**Consultation Response from KC,
Conservation and Design**
2020/93777 east of, Mill Lane, and Heaton Grange, Hanging Heaton, Batley, WF17 6EN
Outline application for erection of residential development
Date Responded:18.12.20
Responding Officer:NG
Responding Ref:

Site Layout Plan

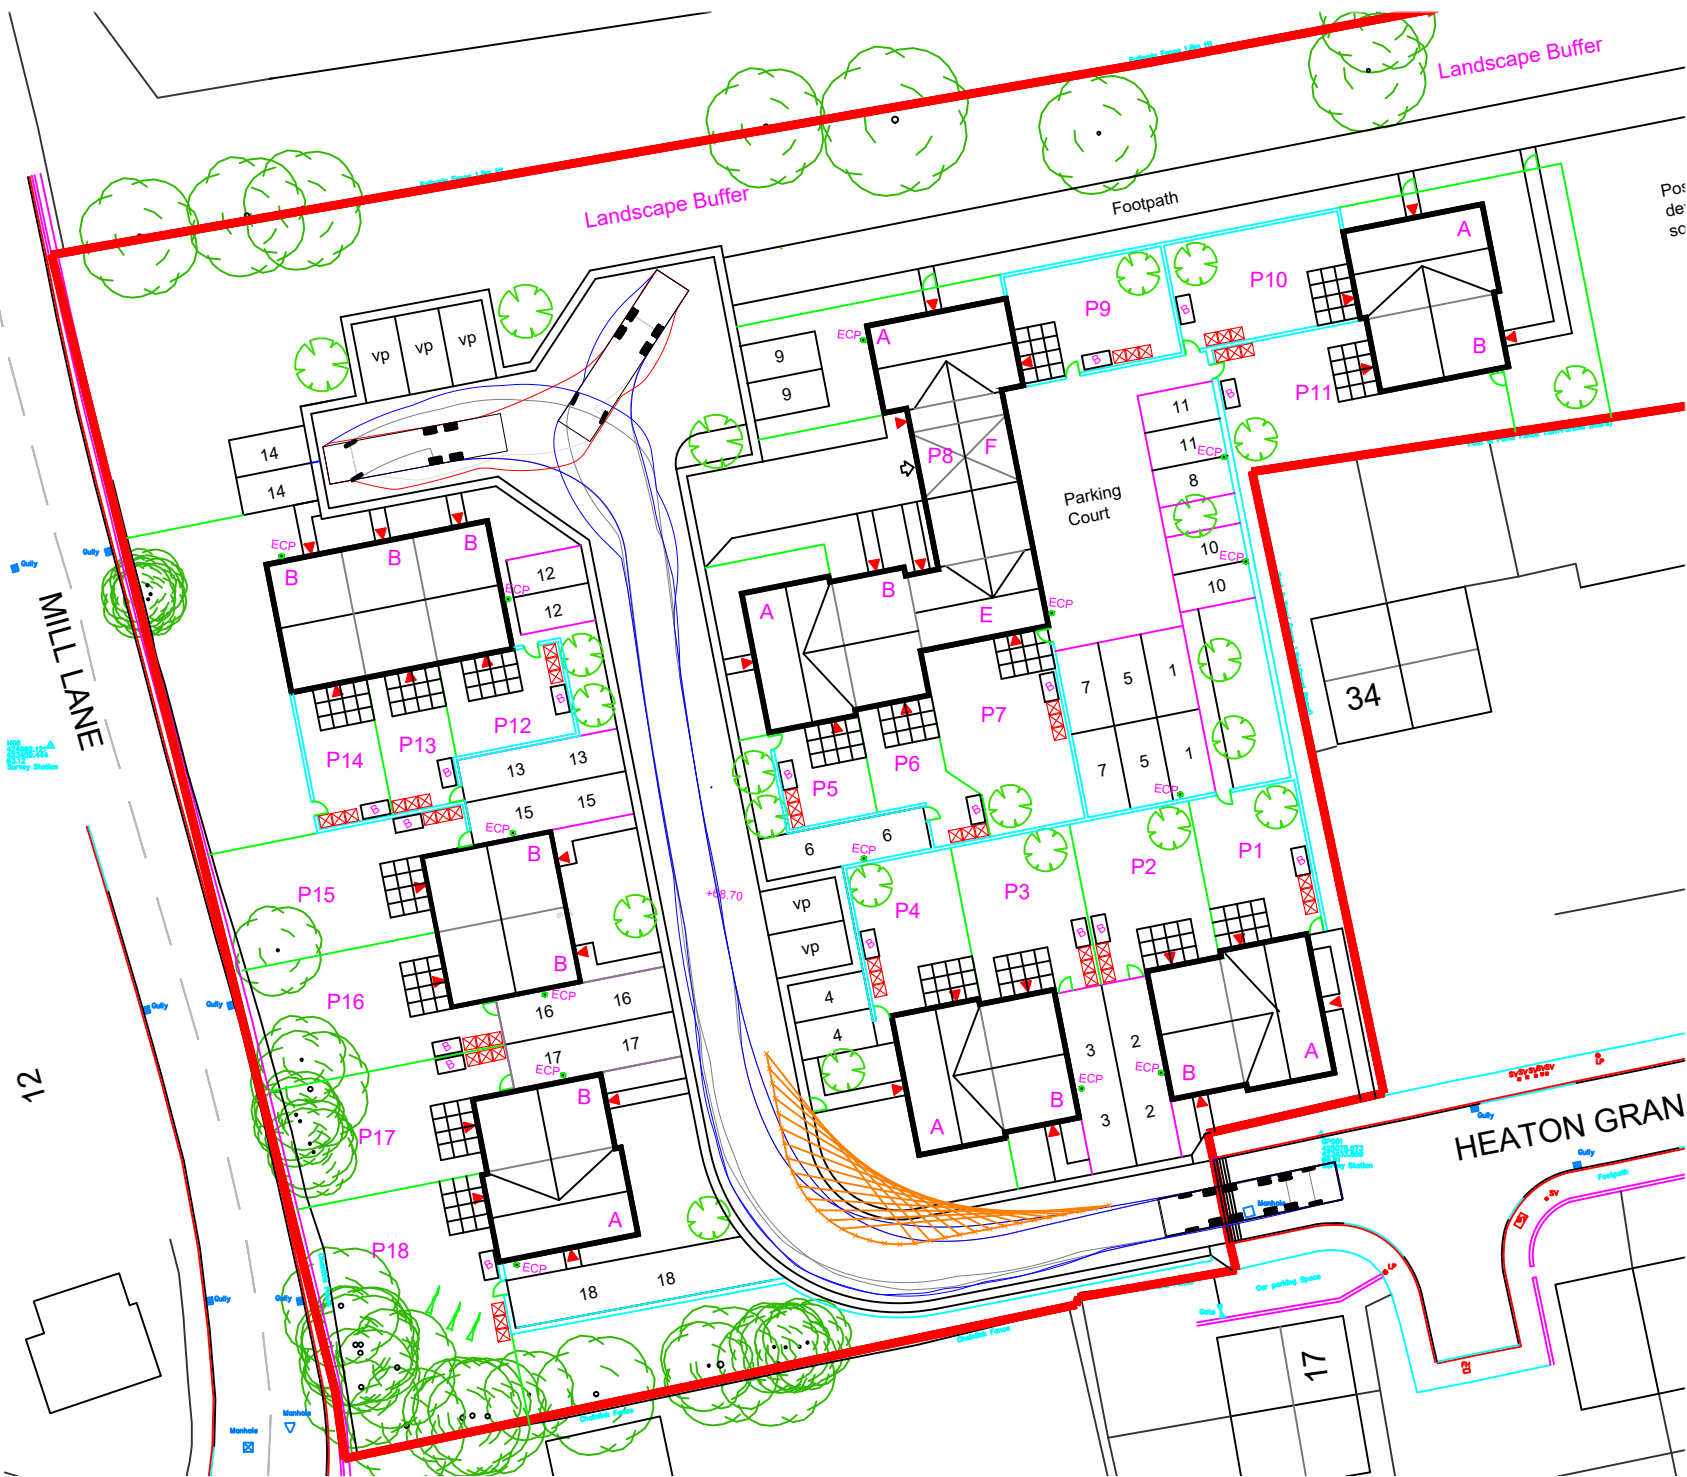
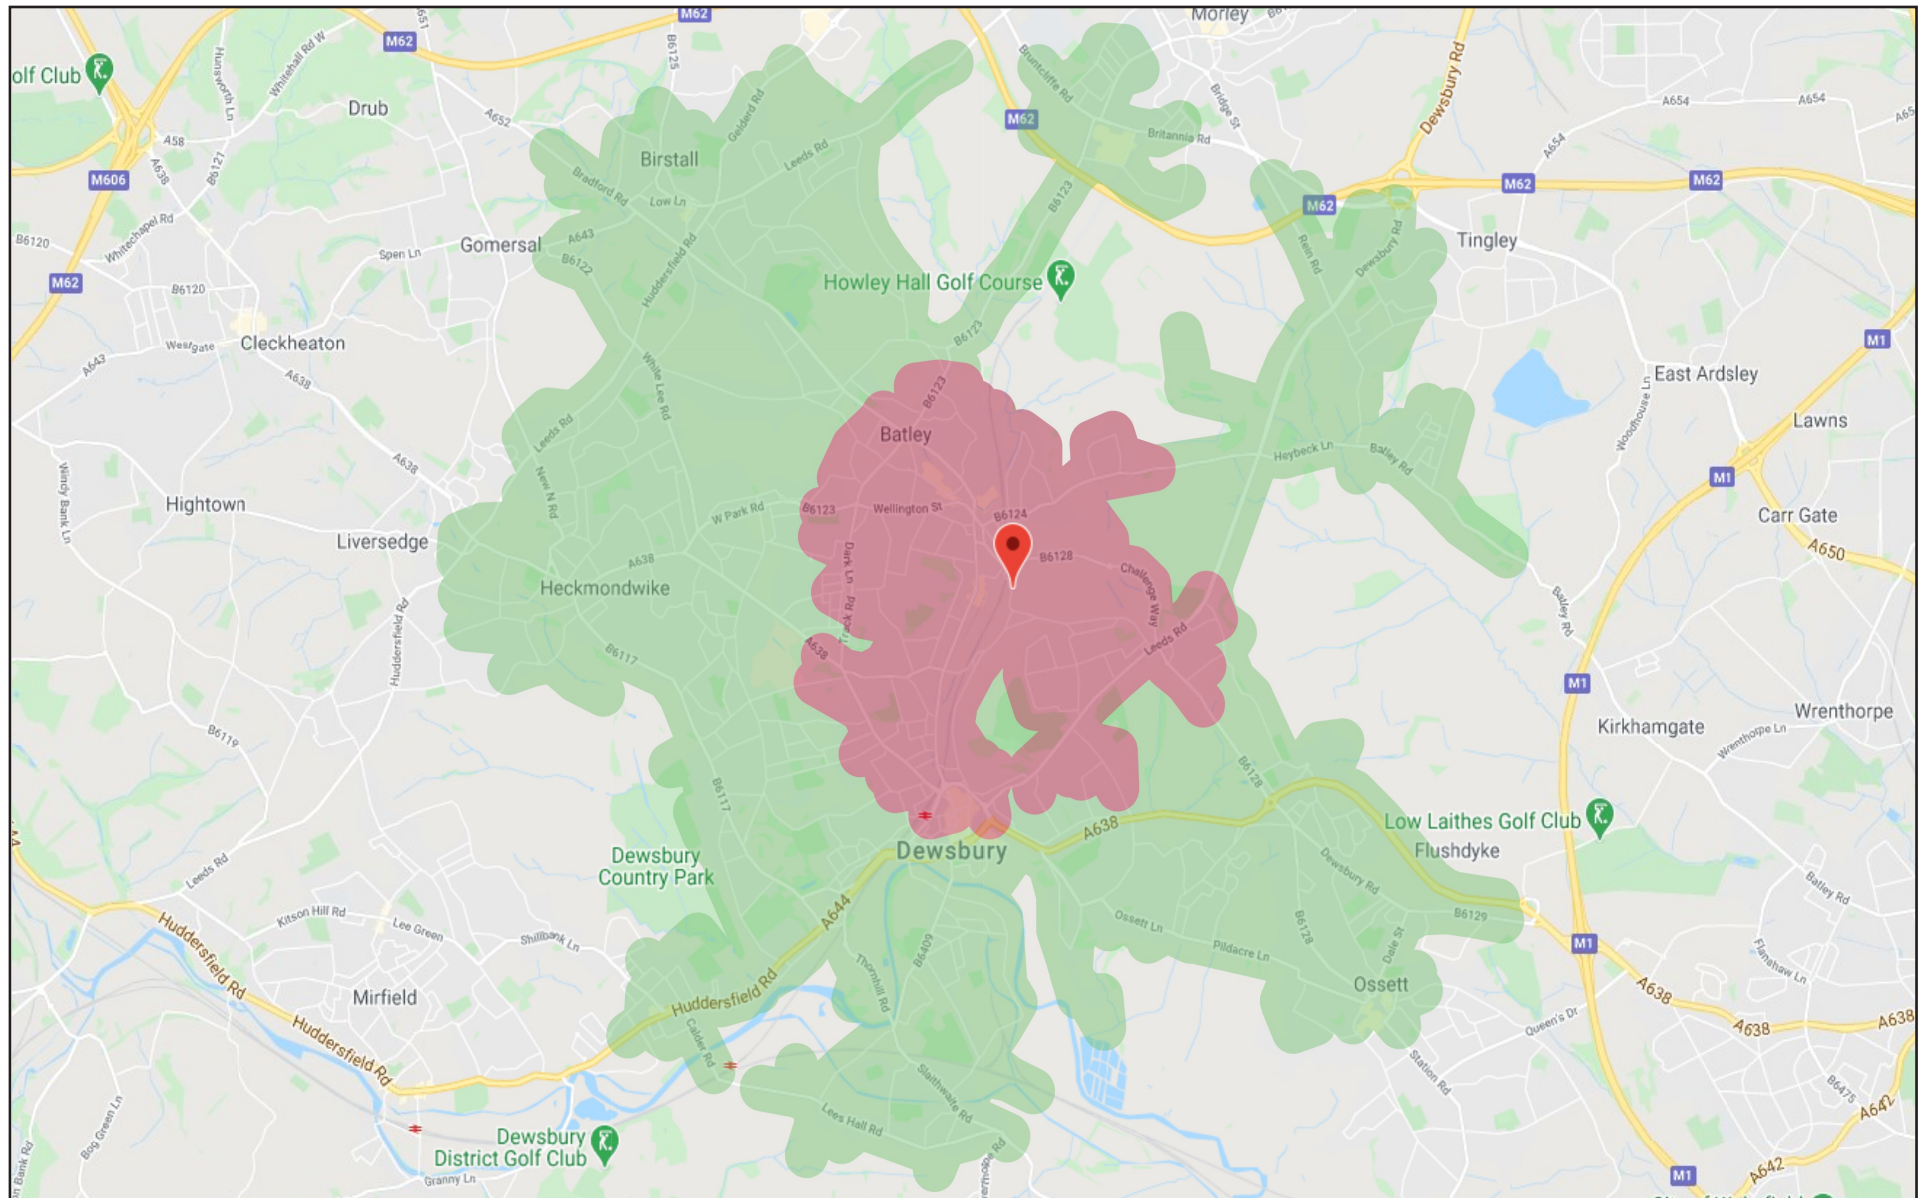
The topography of the site means that the eastern section is roughly at the same height as the rock-stone faced viaduct which is in active use. The indicative housing layout would be arranged at the top of embankment above Mill Lane. The housing layout would have no adverse impact on the understanding or appreciation of the designated heritage asset, or the wider historic environment, despite resulting in a change to the former industrial character of the setting of the viaduct.

The housing location will essentially become a tightly enclosed site at the end of the road network due to the existing topography and development/uses which wrap around the site, resulting in the single access. It is understood that the outline layout is indicative and will require further detailing to enhance the landscaping of the boundaries and the access roads and the amenity spaces. In particular the housing layout should ensure that the access roads are defined by tree planting rather than the hard surface car-parking. The current layout includes inadequate landscaping (essentially just drainage/service easements and the central part of the site is dominated by a shared parking court. I would suggest that given the apparent drainage issues that the parking areas should incorporate more permeable surfaces, SUDS and planting. The trees to be removed will need to demonstrably compensated for by new additional planting. .

Therefore, while the principle of the housing allocation is supported the requirement should be clear that the eventual detailing/Reserved Matters should better accord with the requirements and guidance in the National Design Guide and directly reference the objectives of the Council's emerging Residential Design Guide SPD. The key objective should be to complete the residential transformation of the wider area by creating a high-quality standard for this relatively discreet and intimate area, reducing the hard standing and better integrating the greenspaces into the layout while making appropriate accommodation for wildlife. Therefore, while the residential character is supported the indicative proposal should not be taken to be defining layout due to the need to better integrate the layout into its context, reducing the extent of hard surfaces.
